From: [Wanda Podobnik](#)
To: [Jamey Ayling](#)
Cc: [CDS User](#)
Subject: Public Comments on CU-23-00003, Fowler Creek Guest Ranch
Date: Thursday, October 19, 2023 4:50:11 PM

I am writing in regard to the proposed development for Fowler Creek Guest Ranch, CU-23-00003, and, explicitly, the lack of adequate Domestic Water Plan (Exhibit 8) and Sewage Treatment Plan (Exhibit 9) referenced in the Conditional Use Permit application. Although residing in Spokane, my husband and I regularly visit our son and daughter-in-law's residence located in the Granite Creek neighborhood of Cle Elum.

## EXHIBIT 9.1

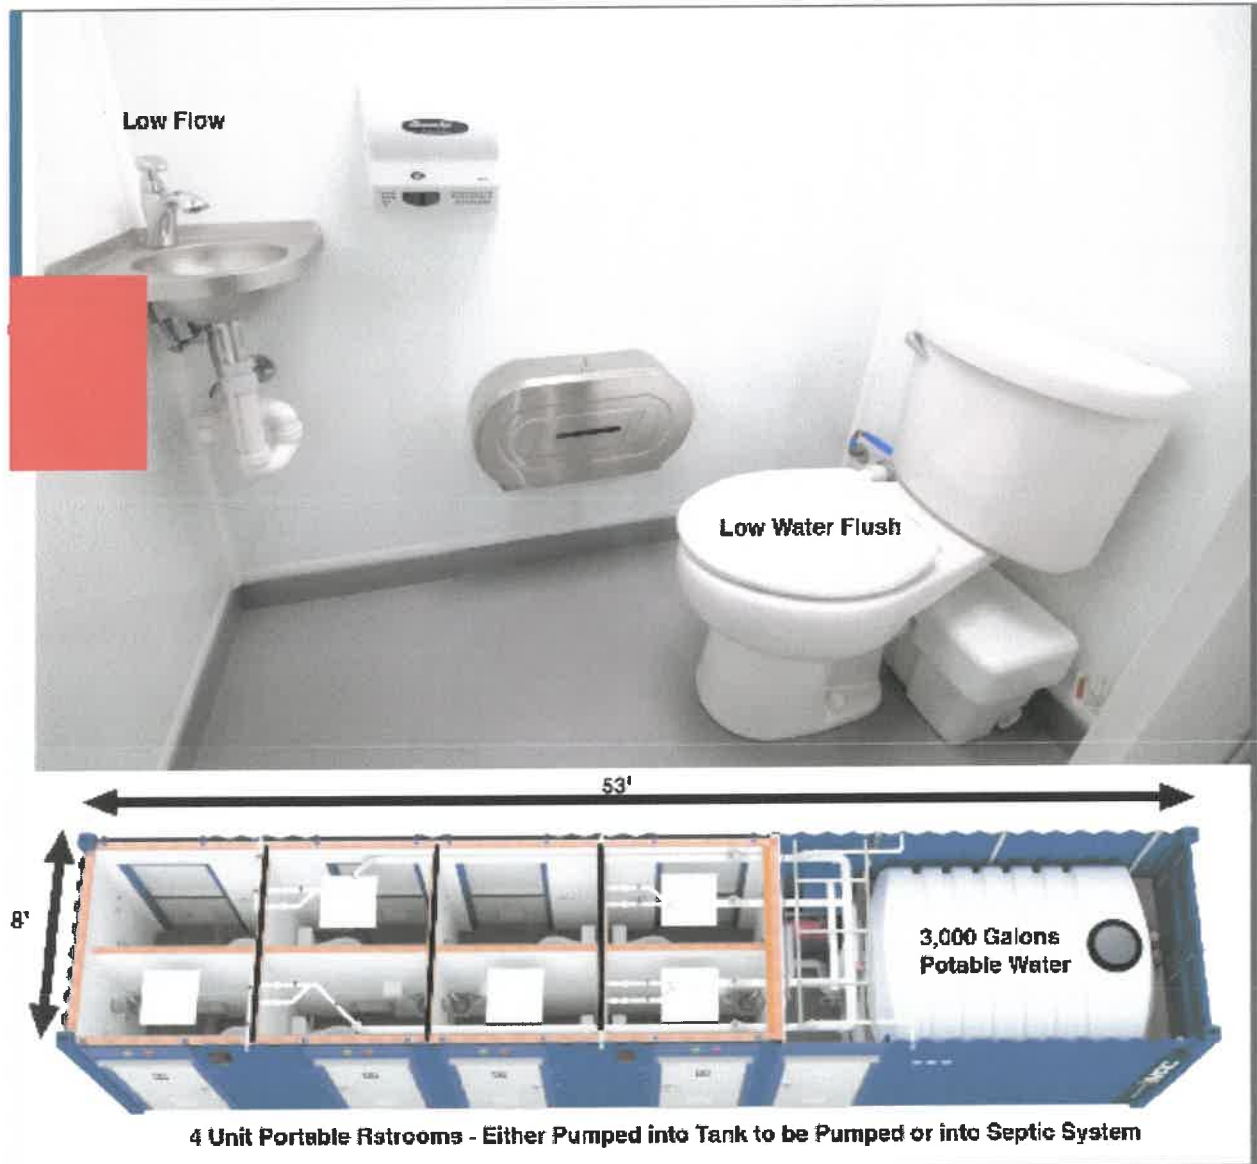
With regard to the Domestic Water Plan (Exhibit 8), it's challenging to ascertain the plan of action as outlined because, based on the information provided by the applicant, there is no plan. Rather, a list of "one or more" possible methods of resolution. As an aside, none of these appear to account for firefighting water, despite the applicant's expectation of visitor campfires located within a wooded, forested area.

SEWAGE MANAGMENT SITE PLAN MAP - FOWLER CREEK GUEST RANCH

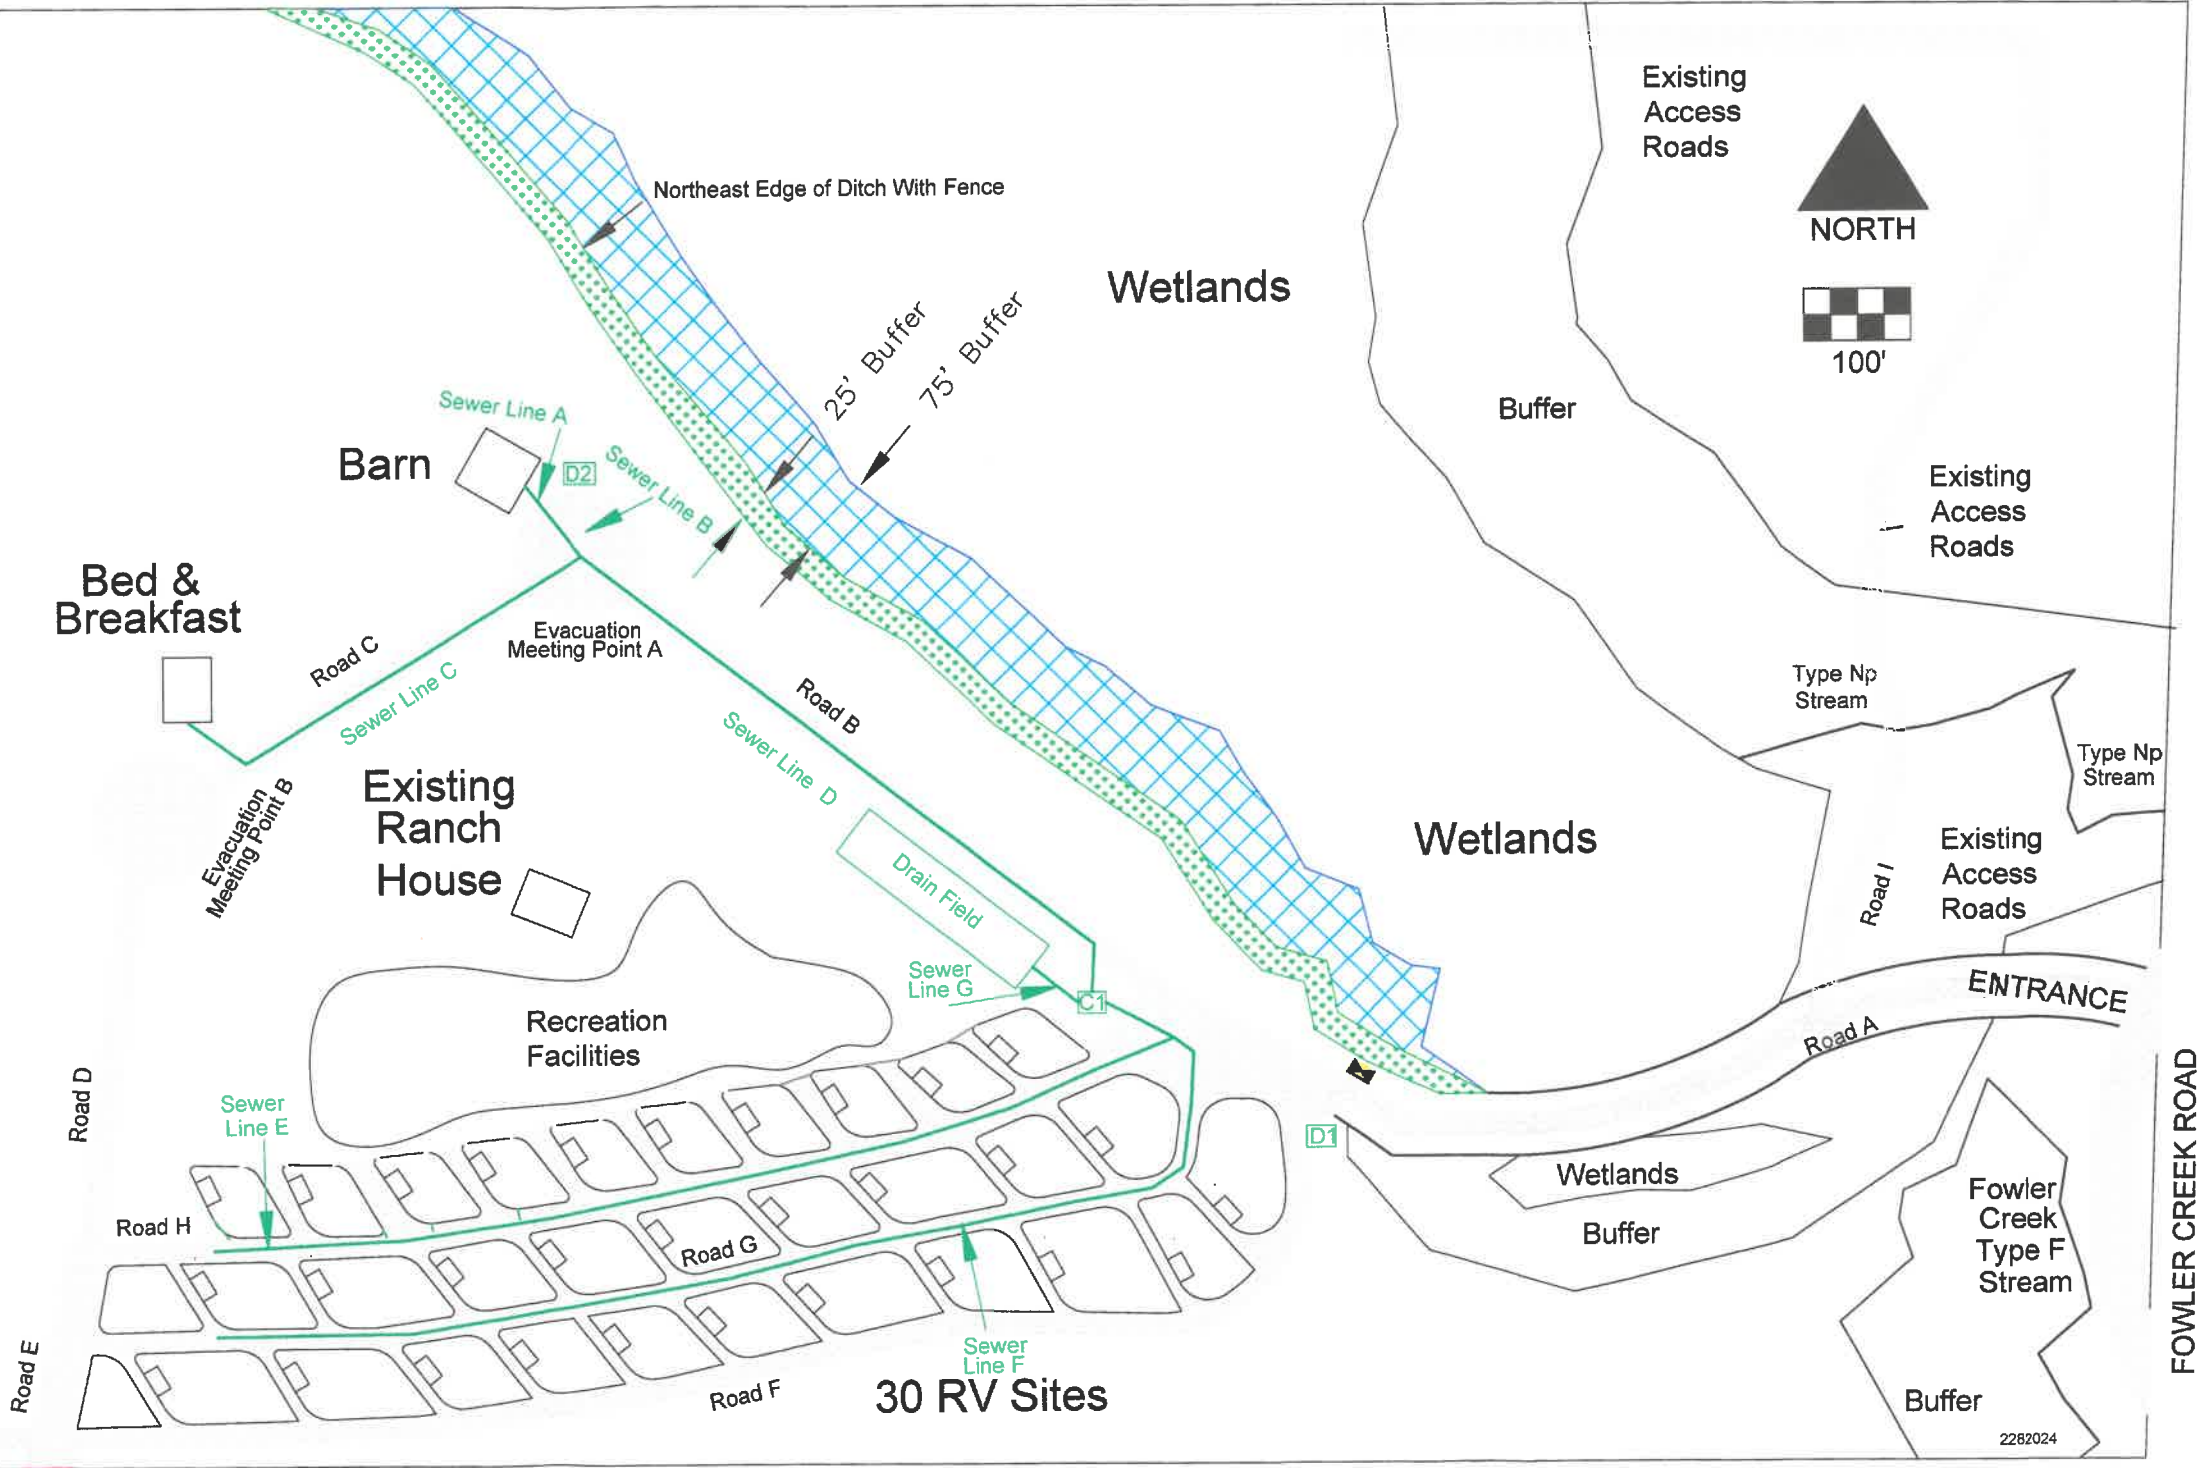
As to the Sewage Treatment Plan (Exhibit 9), while I do not challenge the applicant's approximation of wastewater, given the reference to the United States Geological Survey and publication of "Estimating Water Use in the United States: 2015 Round of the National Water Use Compilation," I will highlight that, as proposed, the wastewater created by a high concentration of short-term visitors in a year round occupation would necessitate a focus on continual rather than seasonal usage. Whether supporting RVs, guest cabins, staff

facilities, or campsites, solutions to contain and mitigate wastewater must actually be pumped far more frequently than that of a seasonal property. Overflow in the event of excess capacity is a common occurrence, as was experienced by the Pinto Point Sewer District, and the ramifications are significant, involving the contamination of ground and groundwater. Given the reliance on private and community wells by nearby residents, this is of particular importance as the proper designation of total population, capacity, and wastewater is critical. I make this point because, while the applicant has cited a calculation of 116 individuals representing 100% capacity, this is clearly inaccurate. By the applicant's own submission, as outlined in Buildings and Recreational Facilities (Exhibit 7), the space also includes an event venue "perfect for weddings, birthday parties, and other special events" yet this addition of 200 additional people is not addressed nor calculated within the Sewage Treatment Plan. Herein, the applicant should account for the increase in population, required capacity, and wastewater created, pushing the population upwards of 300 and the approximation of 6,620 gallons of wastewater per day and capacity required dramatically underestimated. Stated plainly, the addition of 200 additional guests will unquestionably overwhelm the system, resulting in overflow and contamination.
